From: Sandra Hoffman [smhoffman@ohiohills.com]
Sent: Monday, July 02, 2007 7:33 PM
To: Mackenzie Moynihan
Subject: Re: Mildon Short Plat

Our property is adjacent on the west side of the proposed short plat of Ted Mildon, section 12, T17N,R17E,W.M.\

MILDON SHORT PLAT
 PART OF SECTION 12, T. 17 N., R. 17 E., W.M.
 KITTITAS COUNTY, WASHINGTON

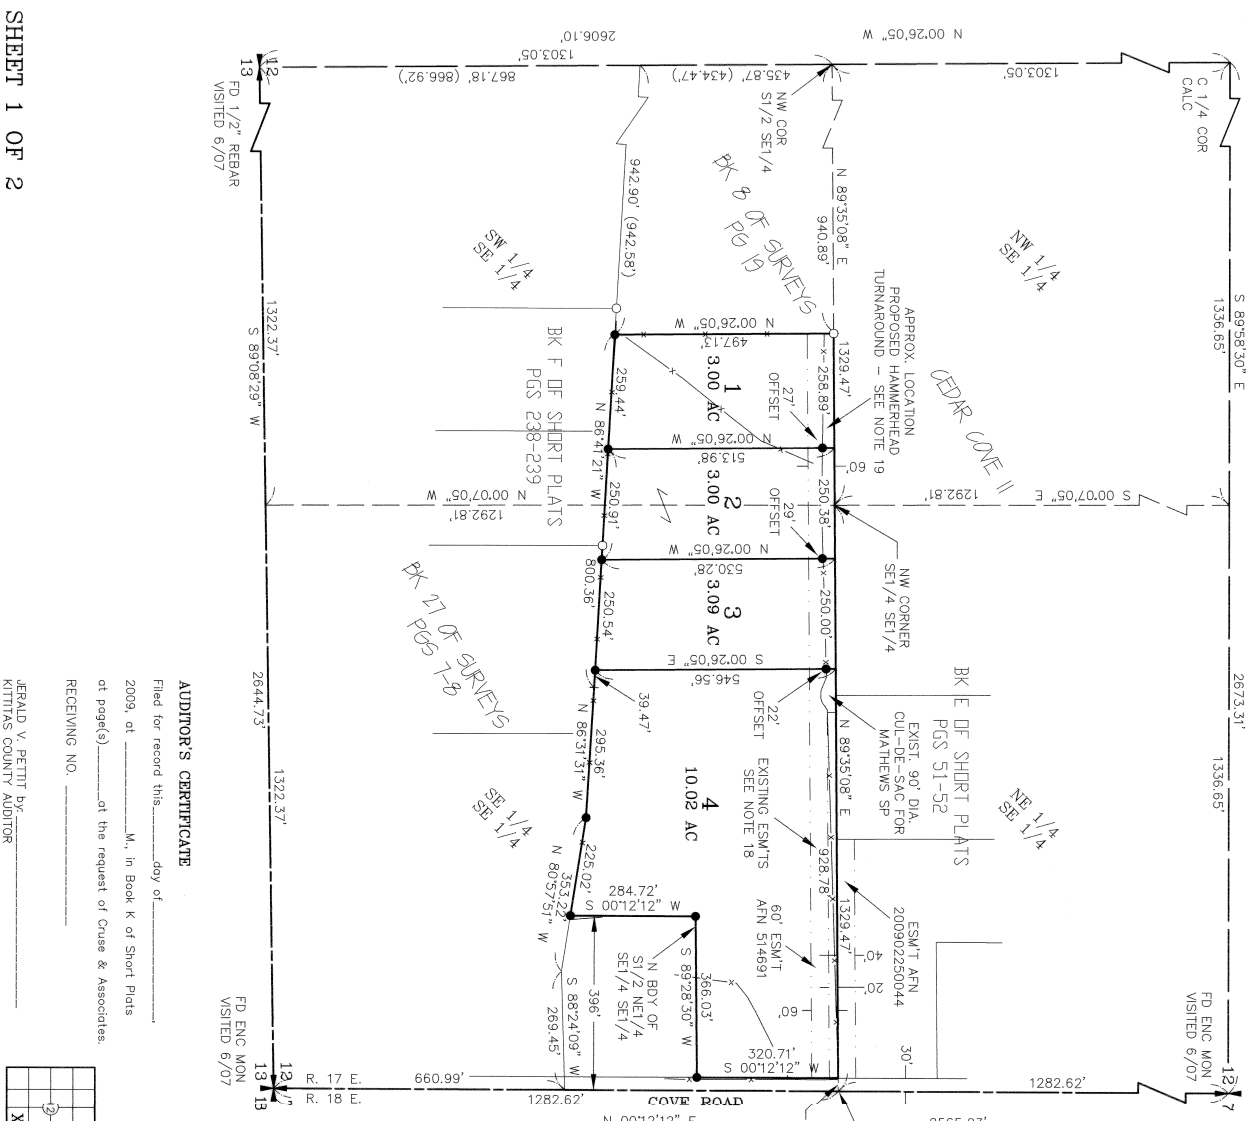
It is unclear to us if the 60' easement identified on the short plat application is the current driveway

shared now with Hoffman, Allen, Miller, Graf, and Skistad or an additional right of way easement

for the new Mildon Short Plat. Does this affect our legal right of way?

If the current driveway is used as proposed in the short plat, that would cause it to serve 9 residences.

If we decide to short plat any of our acreage, that would be 2 more. If the proposed 10.02 acres proposed as

Lot 4 in the short plat is subdivided, that would add 2 more for a total of 13. How would that effect the road

construction requirements?
